**UNITED WAMBO OPEN CUT COAL MINE PROJECT AND HUNTER VALLEY  
OPERATIONS MODIFICATION 5 – CUMULATIVE AIR QUALITY IMPACT  
ASSESSMENT PEER REVIEW**

Date 21/11/2017

Ramboll Environ Australia Pty Ltd (Ramboll Environ) has completed a review of the response to peer review report prepared by Jacobs Group (Australia) Pty Limited (Jacobs) and Todoroski Air Sciences (TAS), dated 9 November 2017.

Figure 1 Time series of 24-hour average PM_{10} concentrations at selected locations

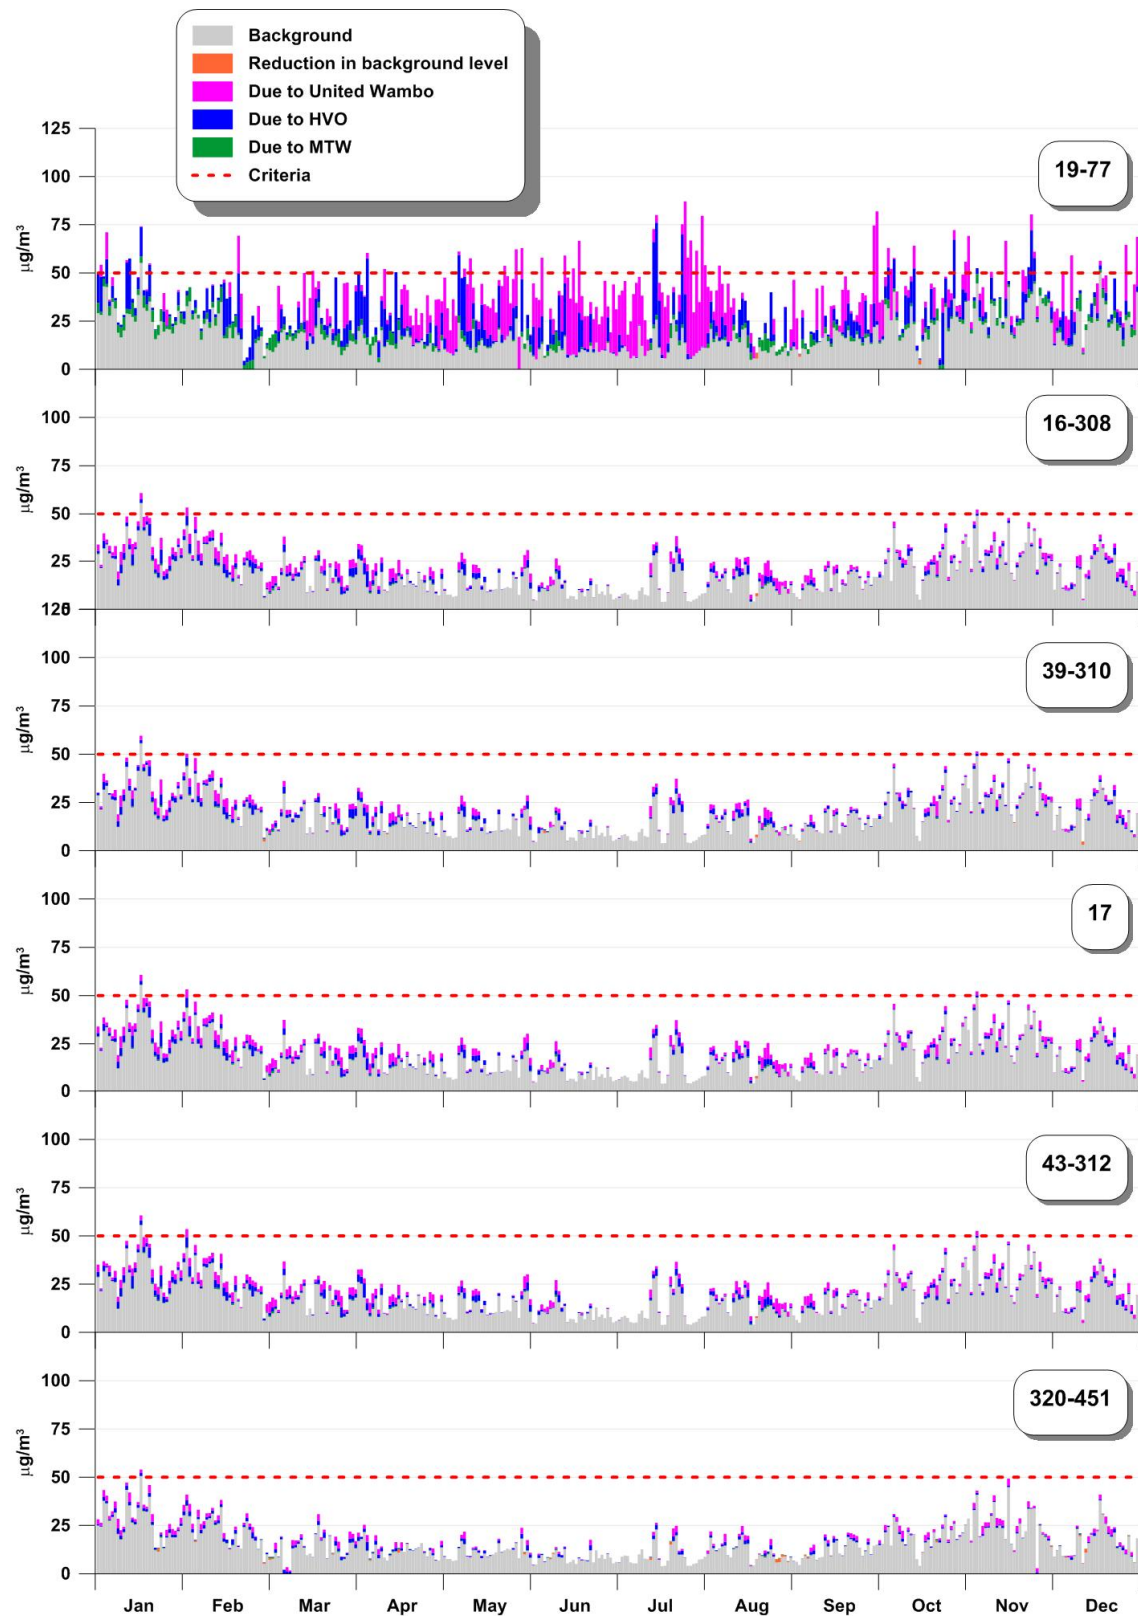
Instead, the Jacobs/TAS response letter provides cumulative time series plots (combining daily-varying concurrent HVOS, UWOC and background concentrations) for the six private receptors considered to be representative of Warkworth Village (19-77) and Moses Crossing (16-308, 39-310, 17, 43-312 and 320-451) and have the greatest potential for experiencing cumulative impacts from the two projects in combination.

For cumulative 24-hour average PM<sub>10</sub>, the most appropriate local monitoring dataset (AQ01 for 19-77, AQ04 for 16-308, 39-310, 17, 43-312 and AQ03 for 320-451 as per the Jacobs/TAS response letter) is combined with the corresponding predicted concentrations from HVOS and UWOC. For receptor 19-77 (Warkworth village), the analysis presents 51 additional exceedances of the NSW EPA assessment criteria beyond those already occurring in the background dataset. As identified by the Jacobs/TAS response letter, this magnitude of additional exceedances highlights that cumulative exceedances would not be avoided at this location.

For the other receptors presented, up to two additional exceedance days are predicted, however these additional days are dominated by elevated background levels. The Jacobs/TAS response letter states that the predicted additional exceedances are consistent with the number of existing recorded exceedance days in local datasets, concluding that the cumulative effects of the two Projects will not significantly alter existing air quality levels in the Moses Crossing area. Ramboll Environ agree with the analysis and conclusions for cumulative 24-hour PM<sub>10</sub>.

Figure 2 Time series of 24-hour average PM_{2.5} concentrations at selected locations

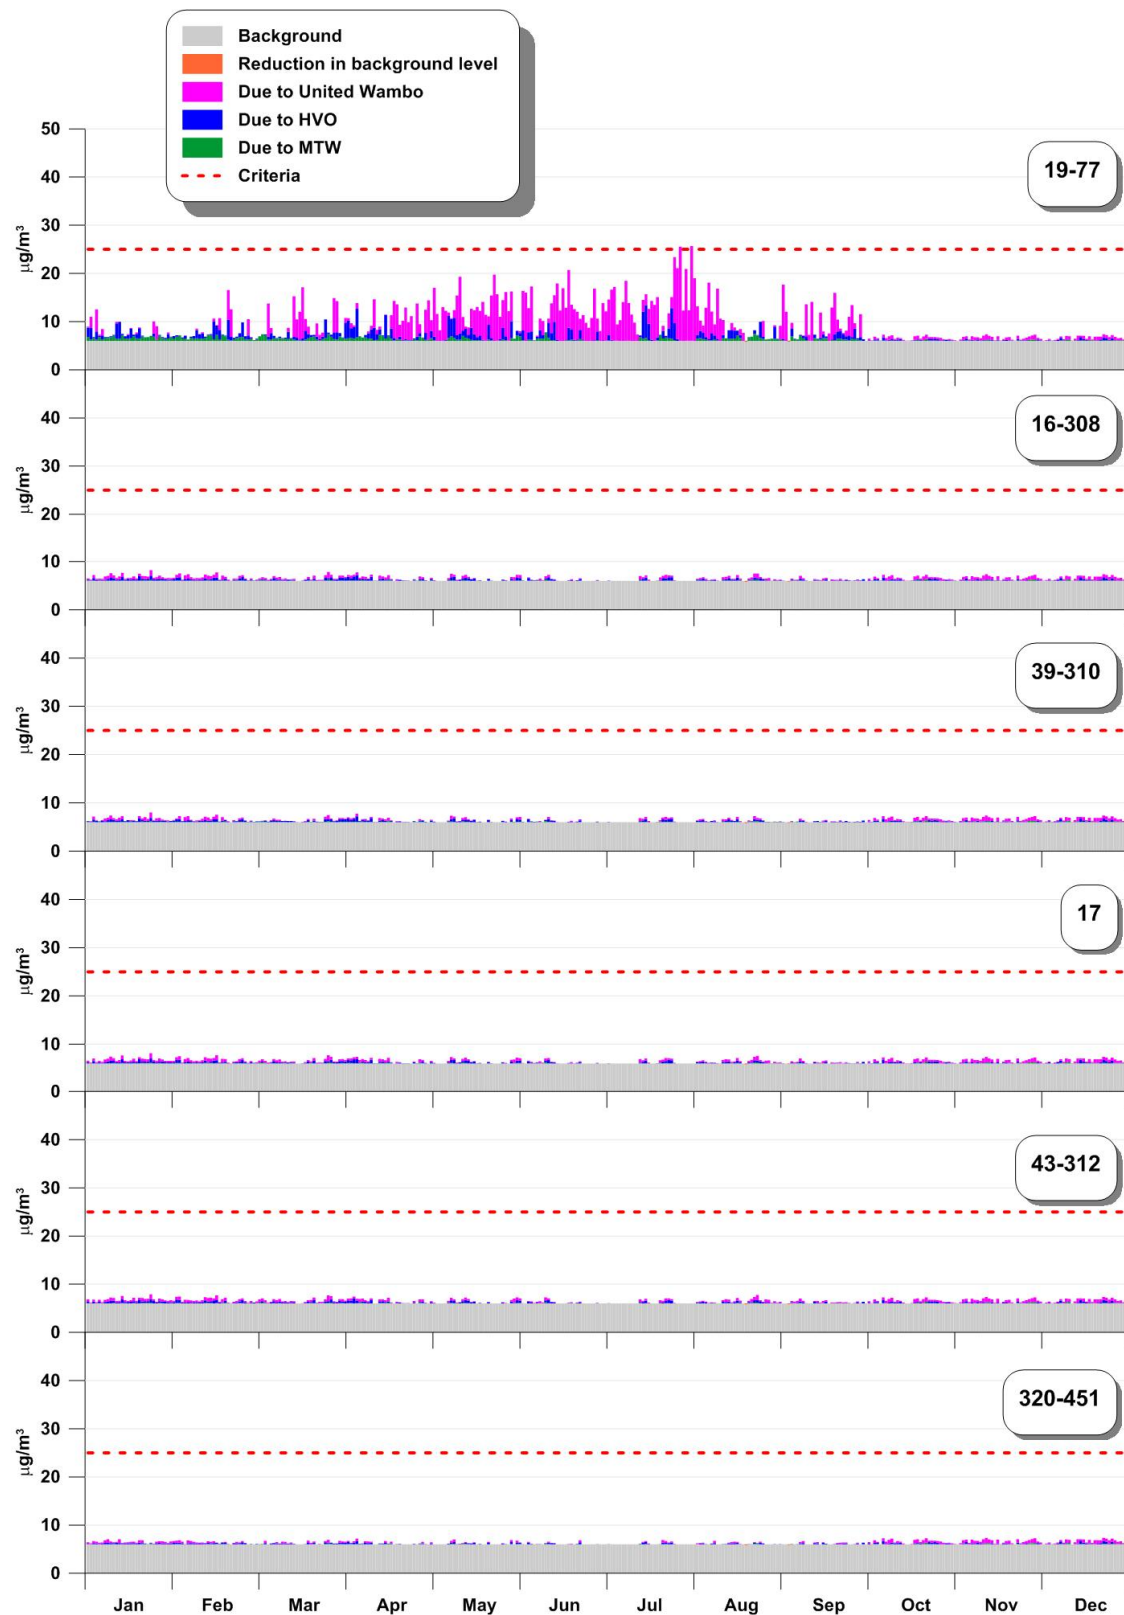
For cumulative 24-hour average PM<sub>2.5</sub>, the time-series analysis was completed using a fixed background concentration of 6µg/m<sup>3</sup> across all days, corresponding to the annual background concentration value that was adopted in the cumulative annual average PM<sub>2.5</sub> analysis. Justification provided in the Jacobs/TAS response letter for the use of a fixed average background concentration was the absence of a suitable local monitoring dataset, however this justification is not accepted. As was recommended for annual PM<sub>2.5</sub>, it is the opinion of Ramboll Environ that combining the relationship between PM<sub>10</sub> and PM<sub>2.5</sub> recorded at the NSW OEH Camberwell monitoring station (not the actual Camberwell measurements) with the daily-varying PM<sub>10</sub> background datasets (I.e. AQ01, AQ03 and AQ04) would provide more rigorous basis for accounting for PM<sub>2.5</sub> background at the receptors analysed.

As was acknowledged for annual PM<sub>2.5</sub>, it is considered unlikely that the recommended changes to background PM<sub>2.5</sub> would alter the ultimate conclusions of the cumulative analysis presented for 24-hour PM<sub>2.5</sub> in the Jacobs/TAS response letter. Predictions at receptor 19-77 aside, the combined HVOS/UWOC 24-hour average PM<sub>2.5</sub> concentrations illustrated in Figure 2 for receptors 16-308, 39-310, 17, 43-312 and 320-451 are low across the modelled period. Nevertheless, this recommendation to revise the background PM<sub>2.5</sub> concentration is made in the interests of improving the scientific rigour of the analysis presented.
